CITY OF ALBUQUERQUE

January 4, 2018

RE: De Anza
Grading Plan and Drainage Master Plan
Stamp Date: 12/13/17
Hydrology File: K17D106

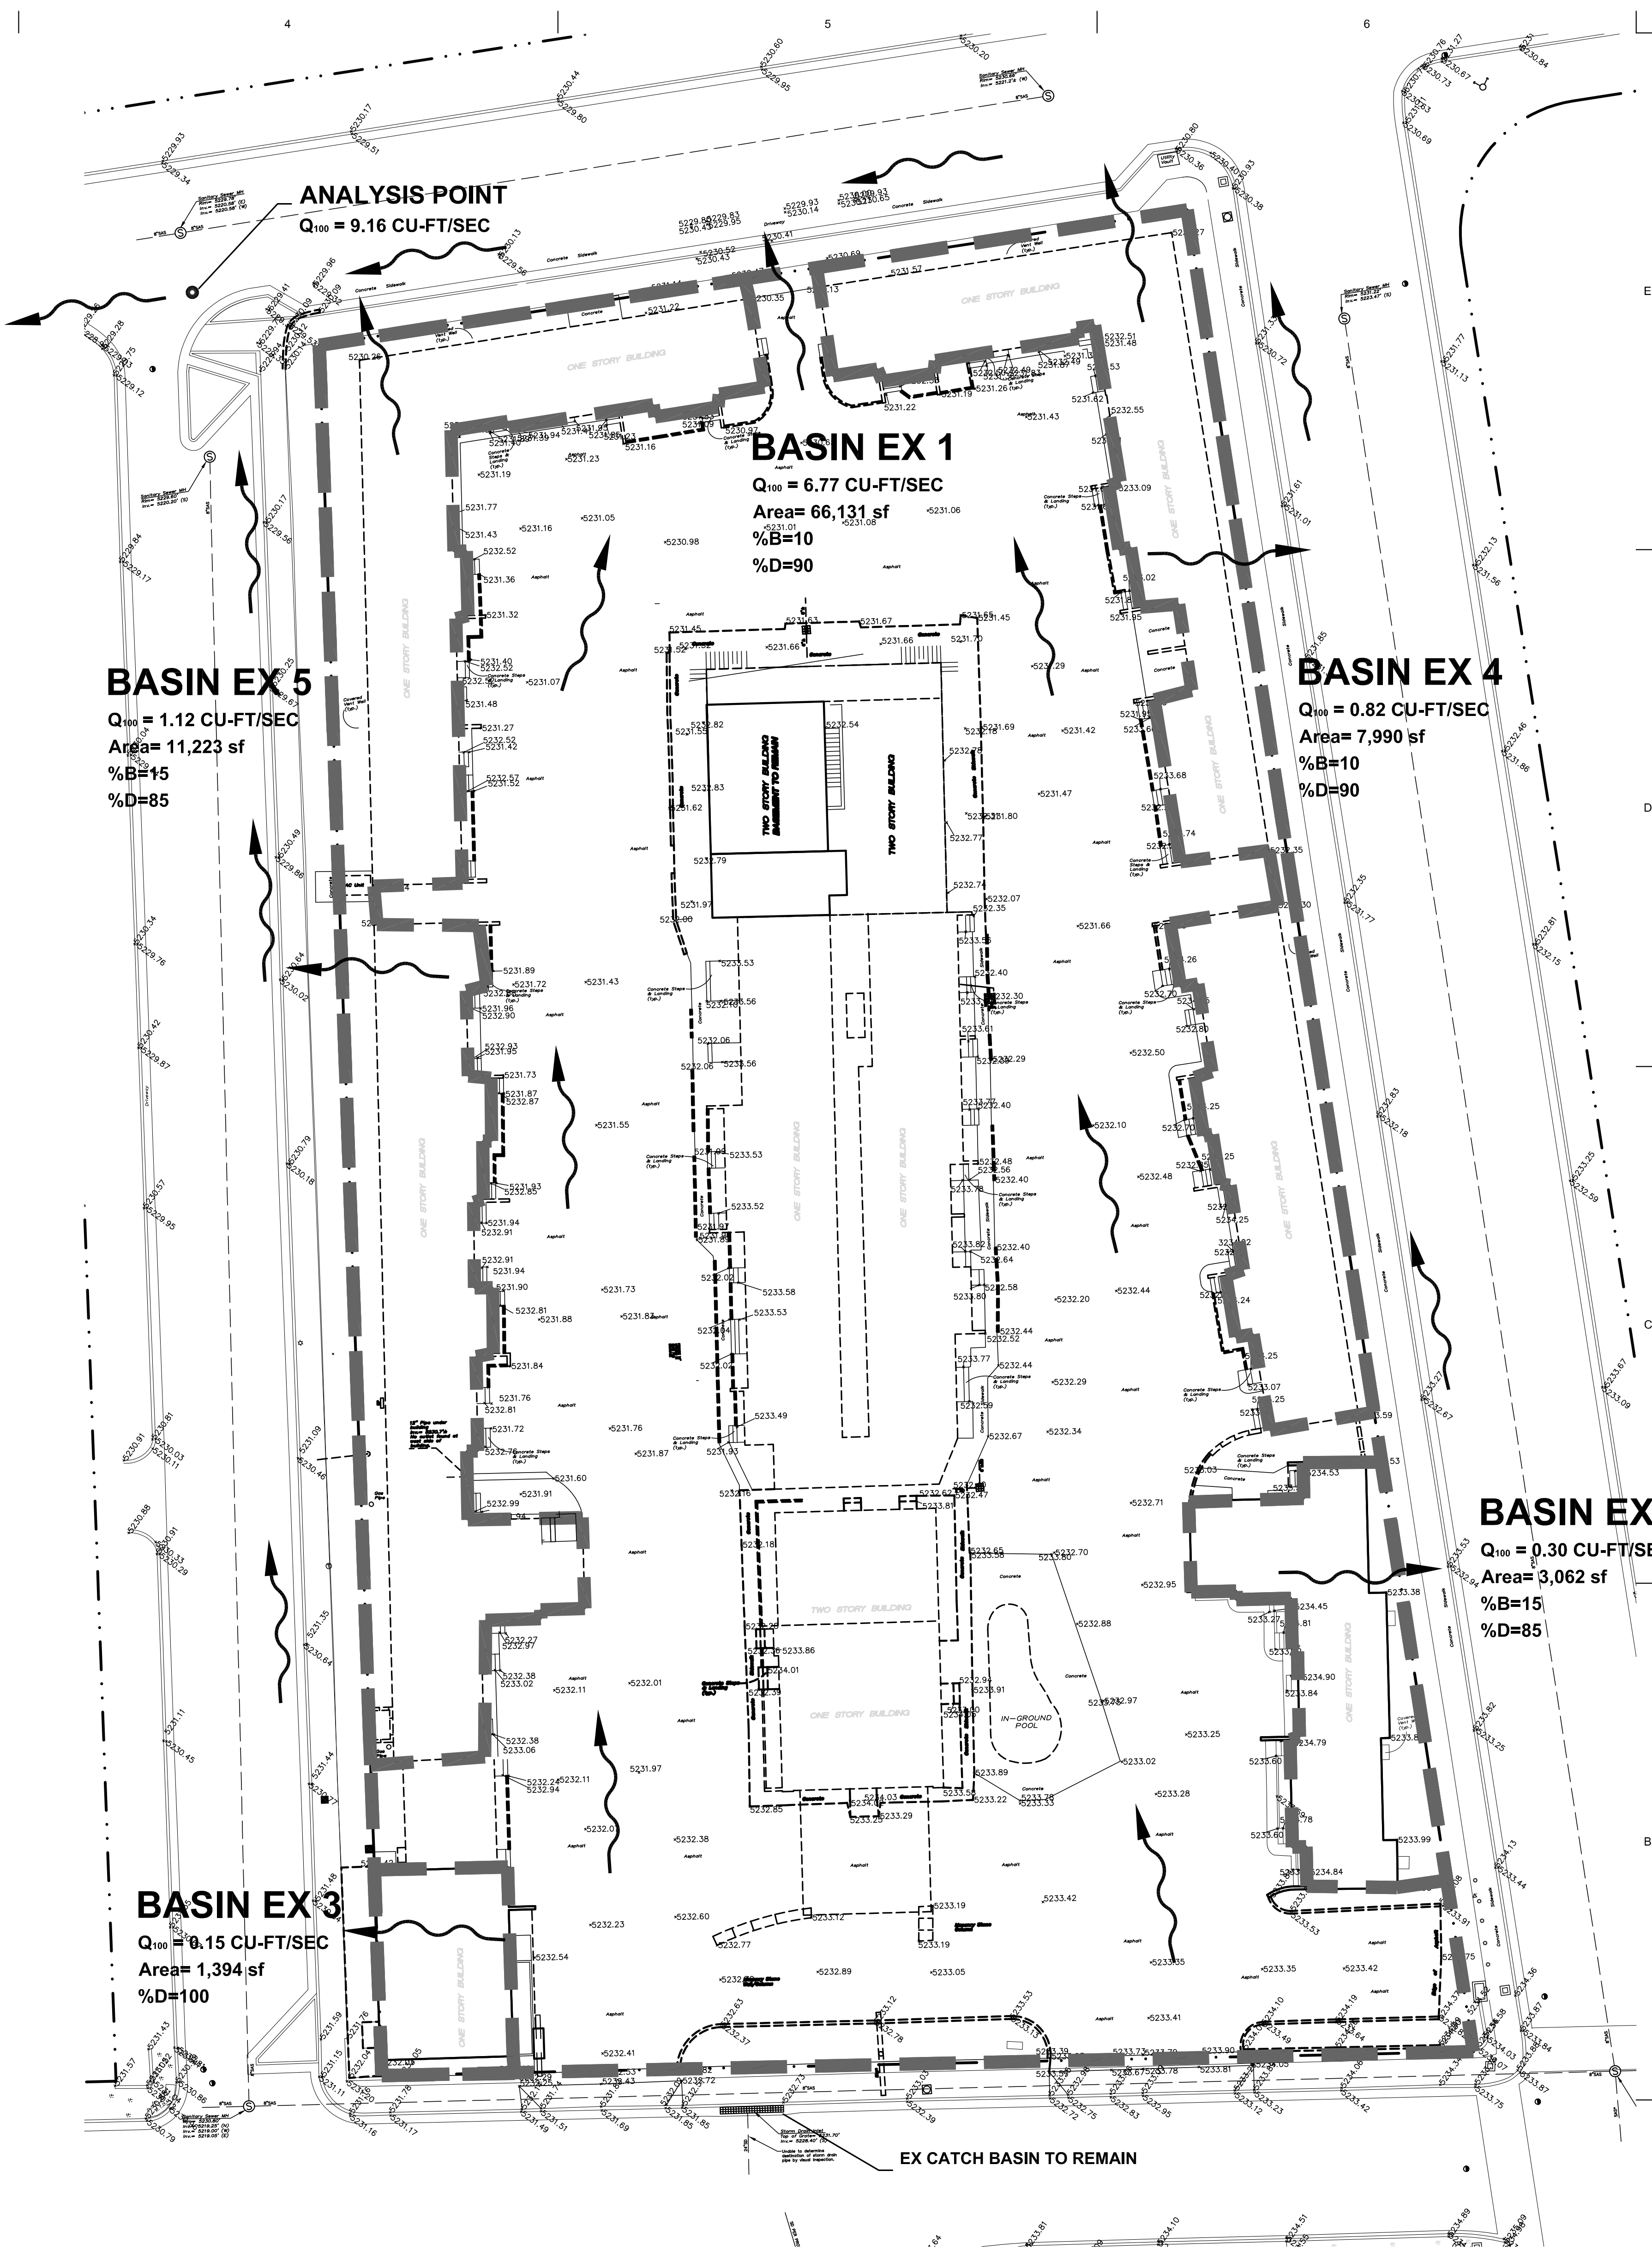
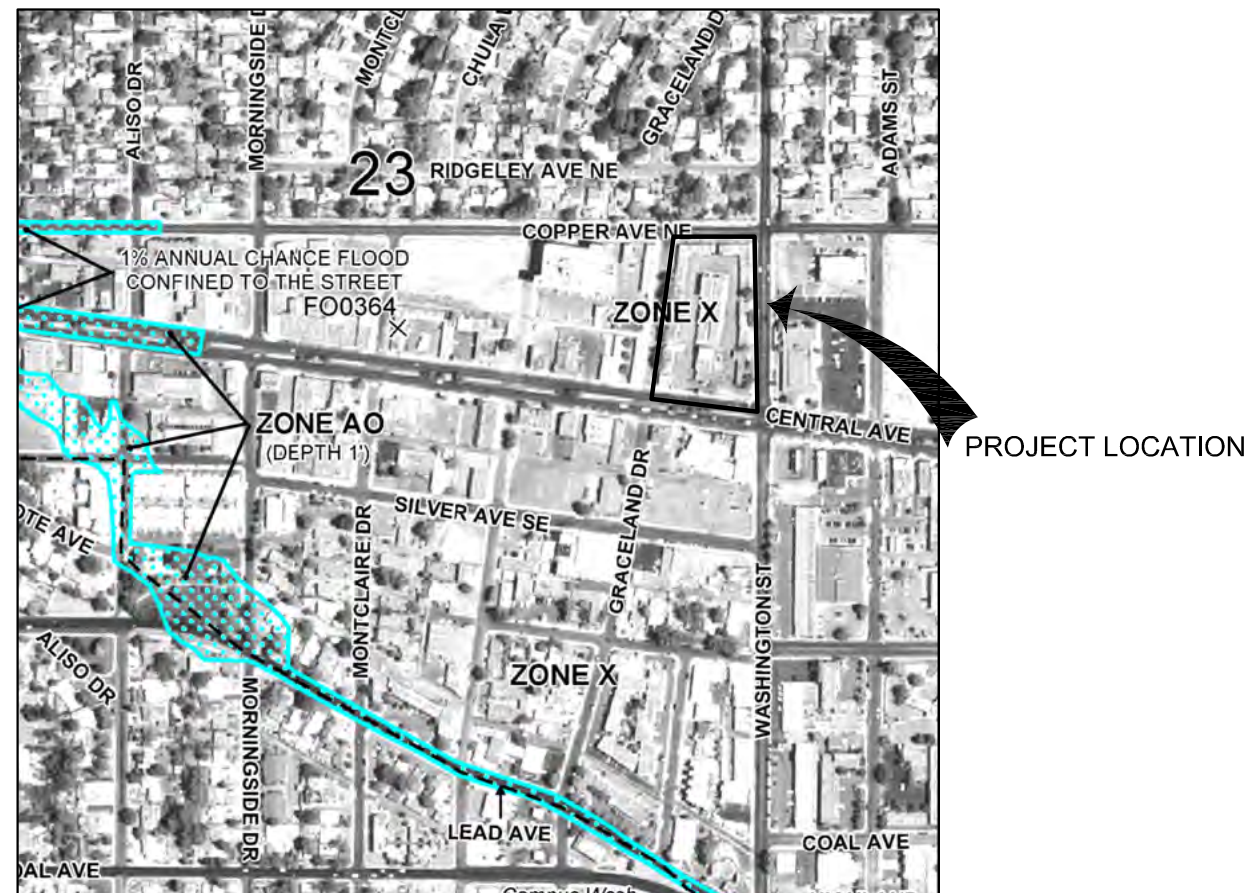
1. Sheet CD1 & CD2. Please provide an engineer's stamp with a signature and date on sheets.

2. The first flush required is 1,571.8 cubic feet. If you want to do the Fee in Lieu, then the payment (Amount = $1,571.8 \text{ CF} \times \$8/\text{CF} = \$12,574.40$) for the required first flush volume must be made. Please add a note on CD1 that states a payment for the Fee in Lieu for the required first flush volume will be made instead of building the first flush ponds.
